15th July 2026
Our Ref: D2380
Planning Ref: BN/64/26/PL

RE: HILL VIEW, EASTERGATE LANE, EASTERGATE PO20 3SJ

We write in response to the Arun District Council drainage consultee comments (10th July 2026) in relation to the above planning application. BP Civils is responding on the applicant's behalf, as their appointed civil engineering consultant, assisting in flood risk and drainage matters in respect of this application.

PL400

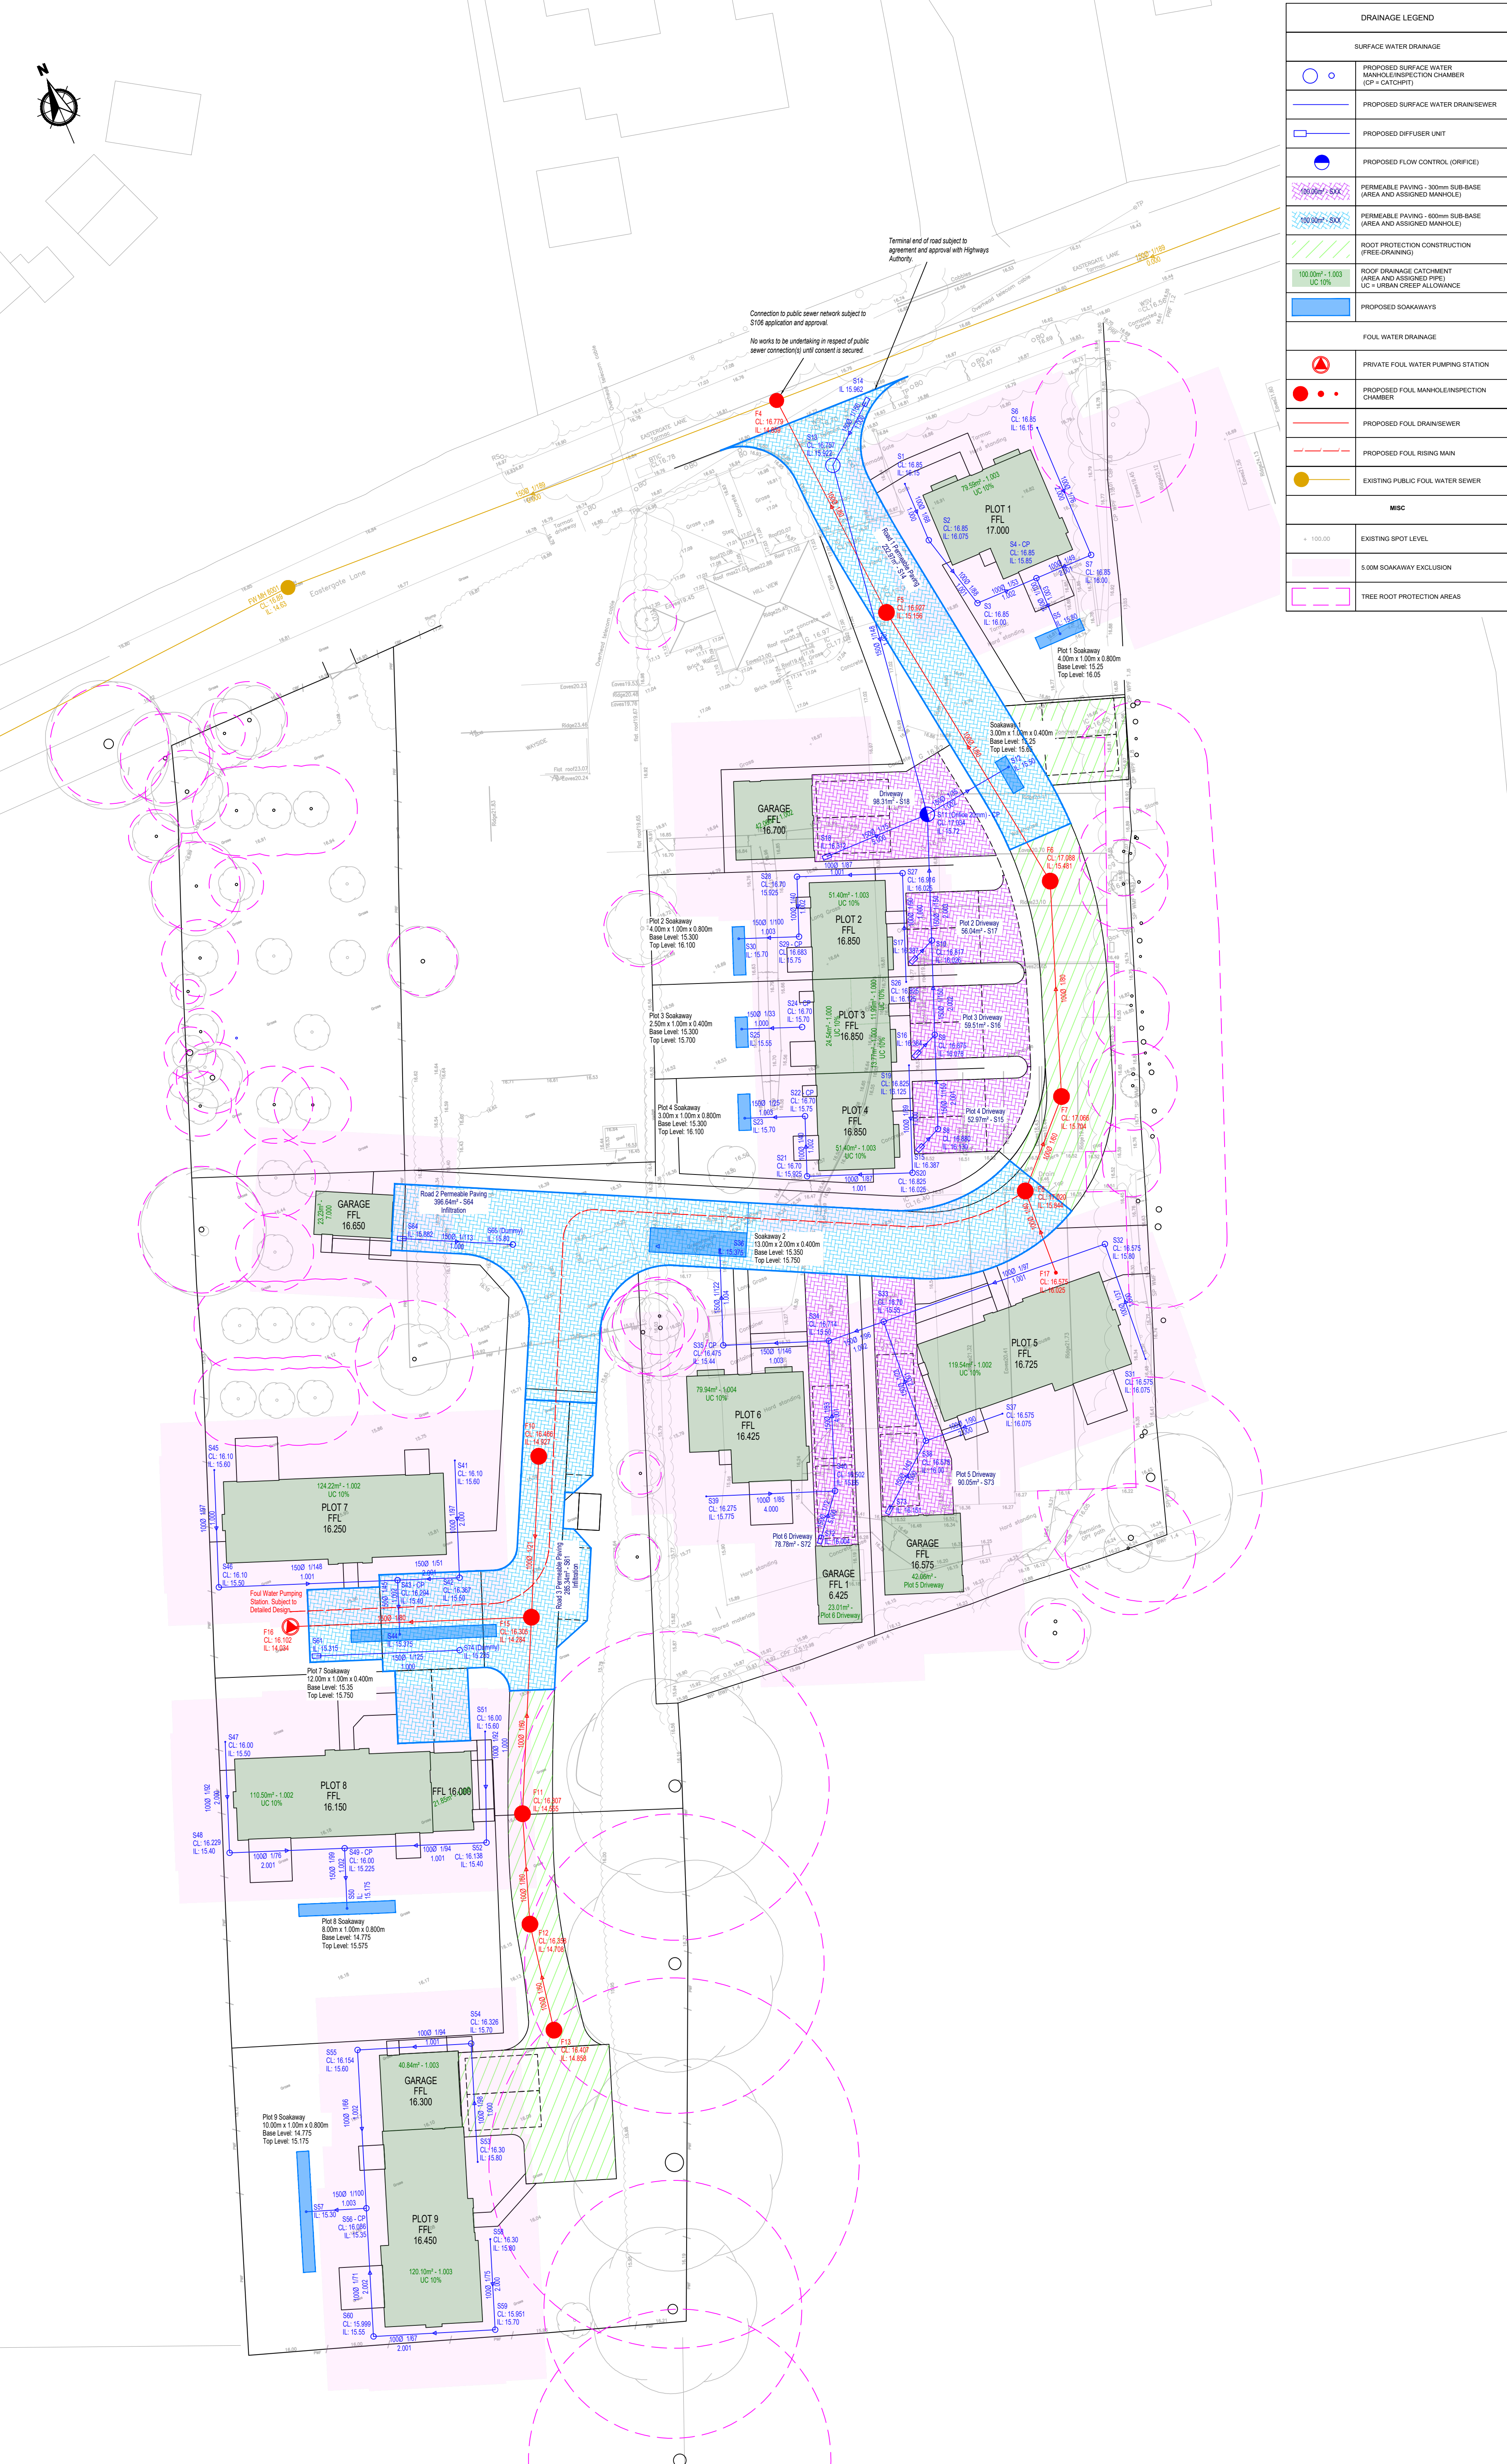
3.5 – Additional calculations are provided for the proposed root protection area construction areas. Dummy nodes have been used to demonstrate this, and do not form part of the proposed on site drainage system. The drainage plan is therefore unaffected. Calculations are provided in **Appendix B**. Our previous written response provided commentary in relation to the depth of stone comment raised by the drainage consultee, and we would refer you back to the earlier response which is still relevant.

3.4 – The output from the modelling software used does not confirm the slope of the permeable paving. This is not something that we have direct control over, therefore we cannot provide this information on the surface water drainage calculation sheets. Screenshots are provided in **Appendix A** from the design software which confirms the slope attributed to each section of permeable paving ('Surface Longitudinal Slope'). The base level of the permeable paving is variable, following the surface level with a fixed sub-base thickness. The base level of the permeable paving is therefore relative to the surface level. Sub-base thicknesses are identified on the drawing in the key, with corresponding hatch colouring to differentiate where sub-base thicknesses differ. Base levels of constant depth are not proposed, and therefore are not shown on the drainage layout. Drawing PL500 'Conceptual Levels' demonstrates proposed site levels. Additionally, as stated in our earlier response, the site is in a wider area which is considered flat, and as such, prevailing falls would not significantly impact upon storage volumes as would be the case on, for example, a steeply sloping site.
